Date: 28-Jan-2025
Our Ref: 2024/93418

**Discharge of details reserved by conditions 3-14, 16-20, 25-28 on previous
permission 2024/90839 for erection of 7 dwellings and associated infrastructure
following partial demolition of existing public house (within a Conservation Area)
Rose And Crown Inn, 132, Knowl Road, Golcar, Huddersfield, HD7 4AN
Application Number: 2024/93418**

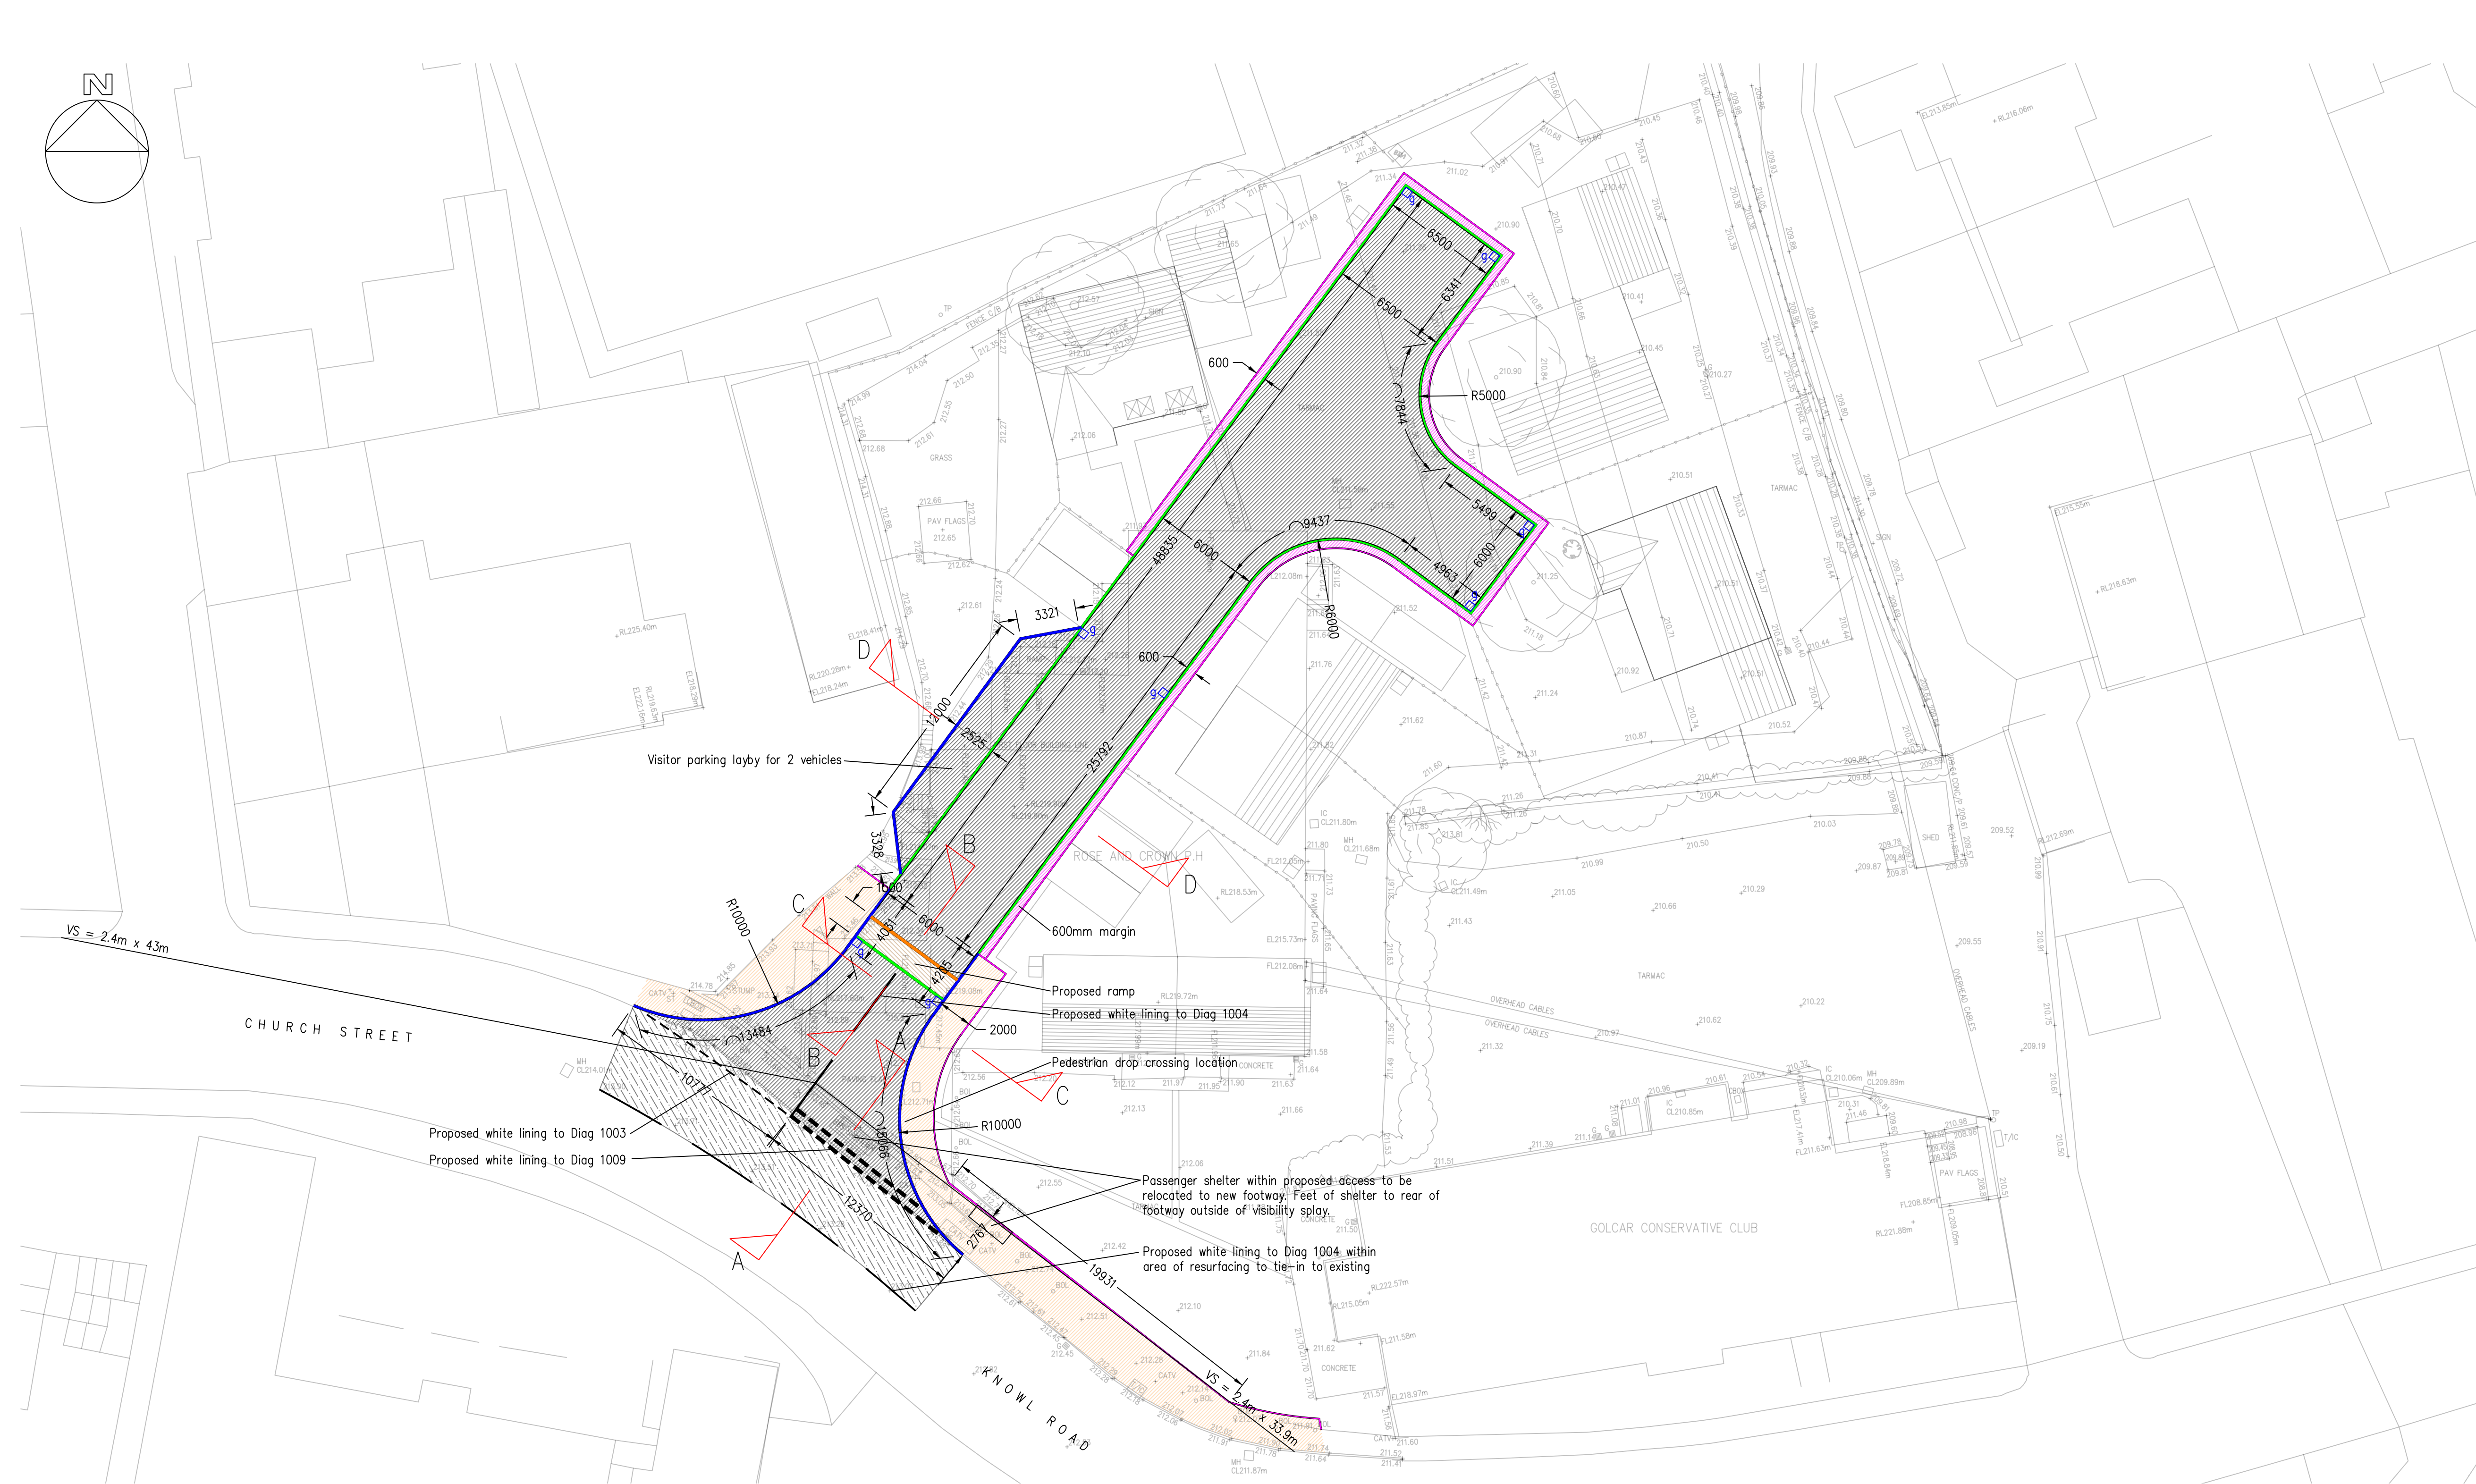
Taking account of the response of the response of the Highways Structures Team it is considered sufficient information to satisfactorily address this condition has not been submitted and this condition cannot be discharged.

Taking account of the response of the response of the Highways Structures Team it is considered sufficient information to satisfactorily address this condition has not been submitted and this condition cannot be discharged.

Conditions 14 and 17 require a separate formal Technical Approval by the Council's Highways Section 38 Team. The council's Section 38 Engineer confirms that the applicants have not made a section 38 Agreement application and these conditions cannot therefore be discharged.
